**RE: TRACT 306 MRGCD MAP NO. 38 (OTC III SUBDIVISION) (J-12/D20)**  
**Engineers Certification for Release of Financial Guaranty**  
**Engineers Stamp dated 10/6/2001**  
**Engineers Certification dated 10/8/2002**

***RE: TR 306, MRGCD MAP NO. 38 (J12-D20), MOUNTAIN & MONTTOYA ROADS NW.  
DRAINAGE PLAN FOR PRELIMINARY PLAT APPROVAL. ENGINEER'S STAMP  
DATED OCTOBER 16, 2001.***

**RE: TRACT 306 MRGCD MAP NO. 38 (OTC III SUBDIVISION) (J-12/D20)  
ENGINEERS CERTIFICATION FOR RELEASE OF FINANCIAL GUARANTY  
ENGINEERS STAMP DATED 10/6/2001  
ENGINEERS CERTIFICATION DATED 10/1/2002**

TITLE DRAINAGE PLAN

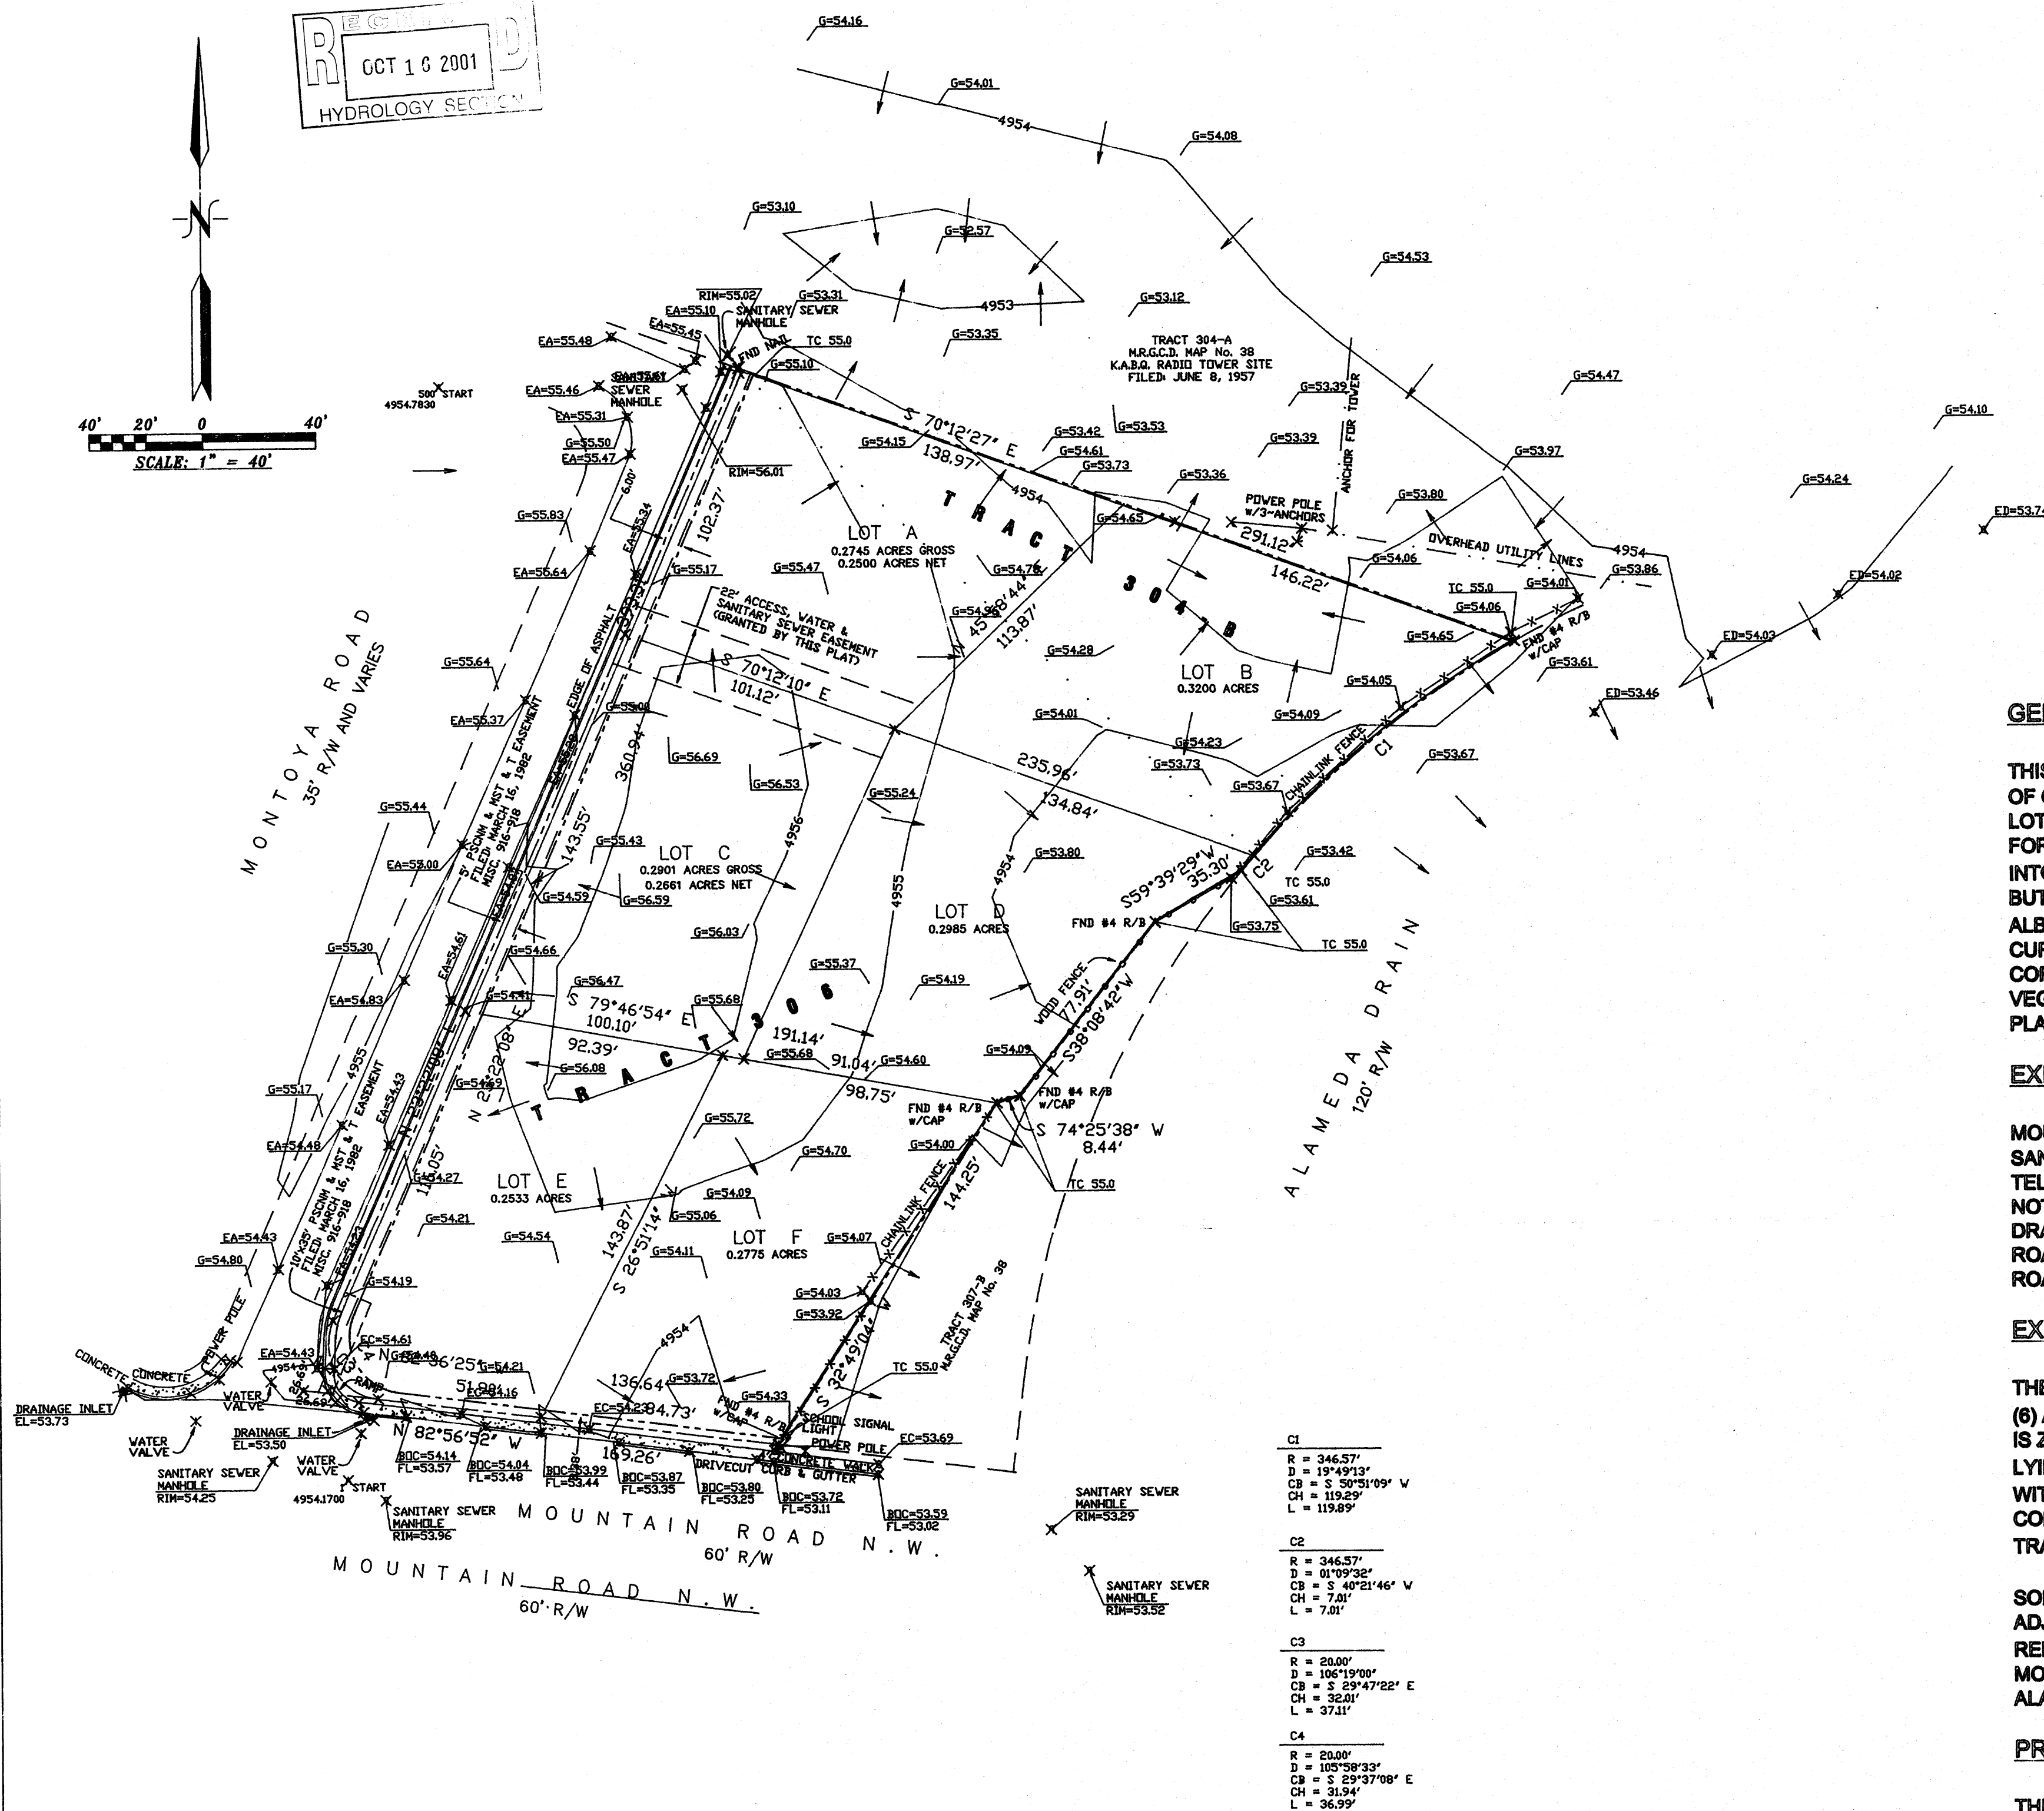
Based on the information provided on your 10/1/2002 submittal, the above referenced project **can not** be approved for Engineers Certification acceptance for release of Financial Guaranty at this time.

As per our conversation on 10/7/2002, the Engineers Certification needs to be expanded to include the wording "...has been built in substantial compliance with the approved grading and drainage plan".
